Application No: FP/70/21/PL
Site Address: Kenwood Court 6 The Midway Felpham PO22 7EZ
Description of works: Erection of a car port and rearrangement of existing parking spaces. This application is in CIL Zone 4 (Zero Rated) as other development.

Thank you for your internet representation made on 4th May 2021 which has been recorded as an objection with the comments as follows:

**PROPOSED CAR PORT
PLANS AND ELEVATIONS**

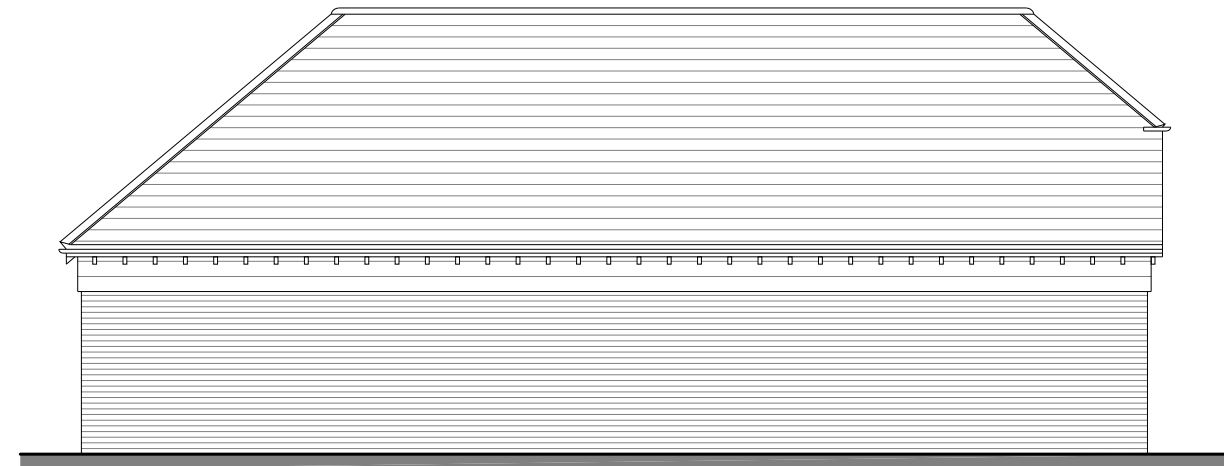
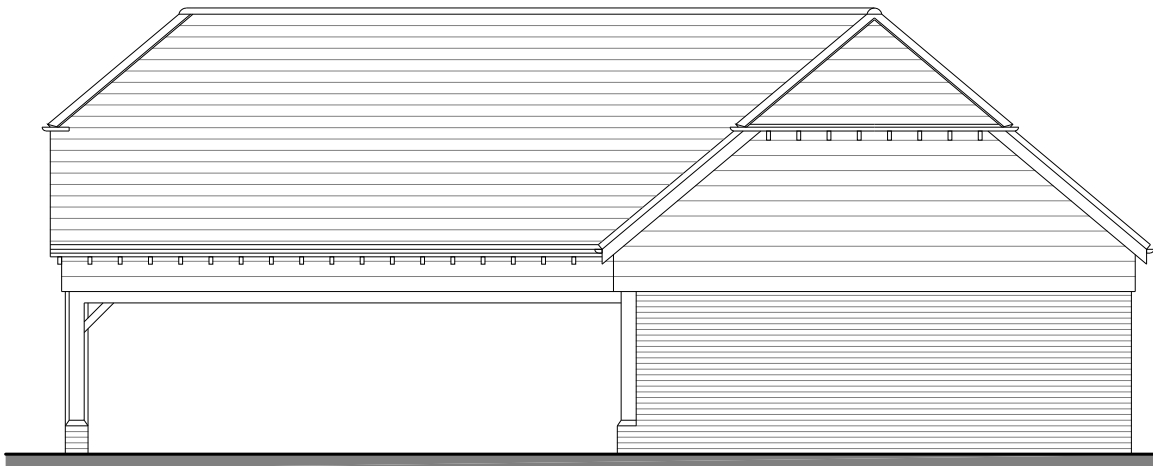
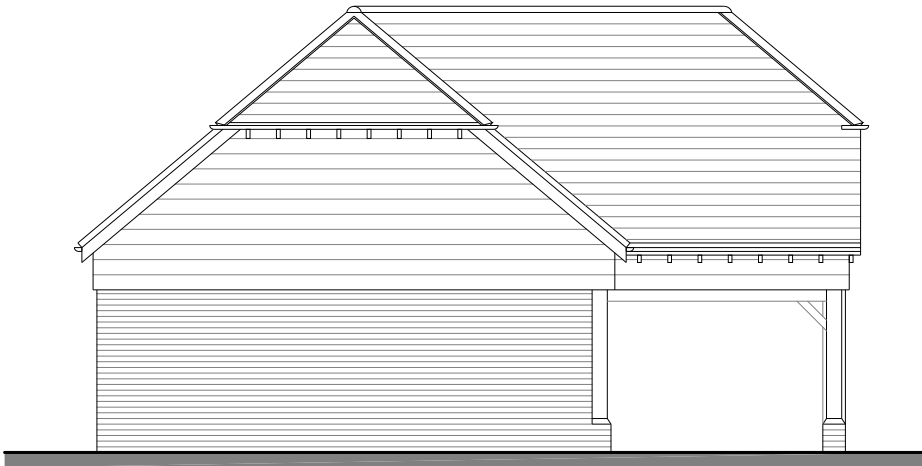
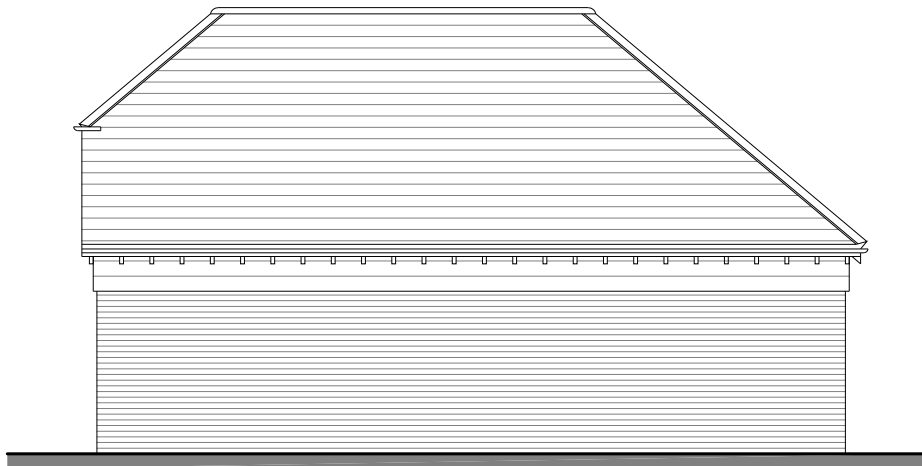
I have looked at the proposed plans and I am seriously concerned about the overall size of the structure. Whilst no height dimensions are shown it appears that the car port is in the region of 6M high. This is not only excessive for a car port but would mean that the building would dominate the skyline from at least 10 of the adjacent properties and severely impair the view of surrounding green space from the gardens
